SFS Response to Submissions

(SSD9249)

Attachment 2- Detailed Response and
Clarifications for Department of Planning and
Environment

Attachment 2 – Response to DP&E Letter dated 20 July 2018

Cross Section of Typical Sediment Basin.

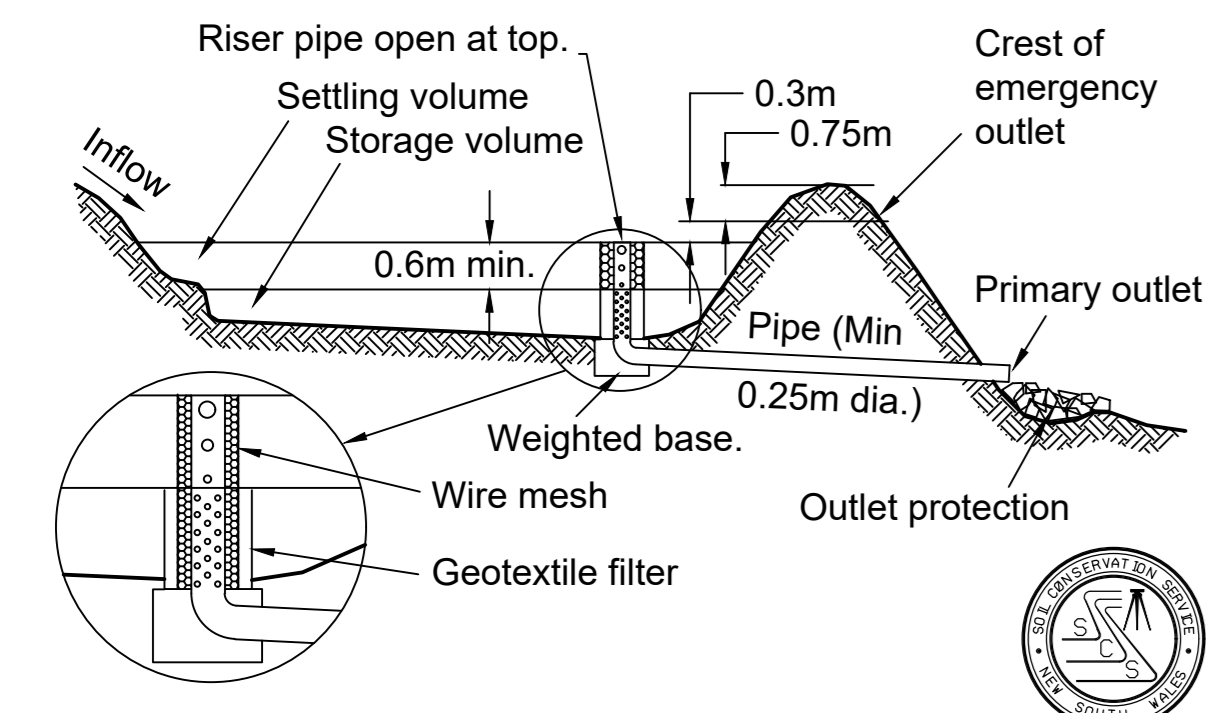
Construction Management Plan (CMP)	
DPE24	It is unclear whether the location of the sediment basin in the Sediment and Erosion Control Plan, would require excavation, noting that the proposal does not seek approval for any excavation works on the site.	Demolition works will be completed to slab level only. No excavation is proposed as part of the Stage 1 works. A revised Sediment and Erosion Control Plan is included at Attachment 10 of this Response to Submissions.
DPE25	The Sediment and Erosion Control Plan needs to be amended to be specific to the demolition phase only.	A separate sediment and erosion control plan has been prepared for Stage 1 to illustrate the proposed arrangement. Refer to Attachment 10 of the Response to Submissions.
DPE26	The CMP must be amended to include clear and measurable environmental performance objectives for the demolition phase. Trigger, Action, Response criteria and processes should also be outlined for each relevant potential impact (e.g. dust leaving the site, stormwater flows from site entering Kippax Lake etc.).	<p>Section 11 of the Construction (Demolition) Management Plan provided at Appendix E of the EIS includes procedures for emergency and crisis management including environmental issues. The framework includes procedures for detecting an incident, addressing the incident and implementing responses for avoiding future incidents. Additional information regarding the Environmental Performance Objectives and the response and mitigation measures is included at Section 4.6 of the Response to Submissions.</p> <p>We note that a detailed Demolition and Environmental Management Plan will be prepared prior to the commencement of works. This commitment was included as a Mitigation Measure at Section 8.0 of the EIS. This is consistent with the conditions of approval for Western Sydney Stadium. To specifically address the matter raised by DP&E, the Mitigation Measure has been expanded in the Final Mitigation Measures included at Section 5.0 of the Response to Submissions to explicitly require that the DEMP addresses the matters identified as Environmental Performance Objectives and in the Construction (Demolition) Management Plan. Additional mitigation measures to enable monitoring and measuring of potential dust and noise impacts have also been included in the Final Mitigation Measures at Section 5.0</p>
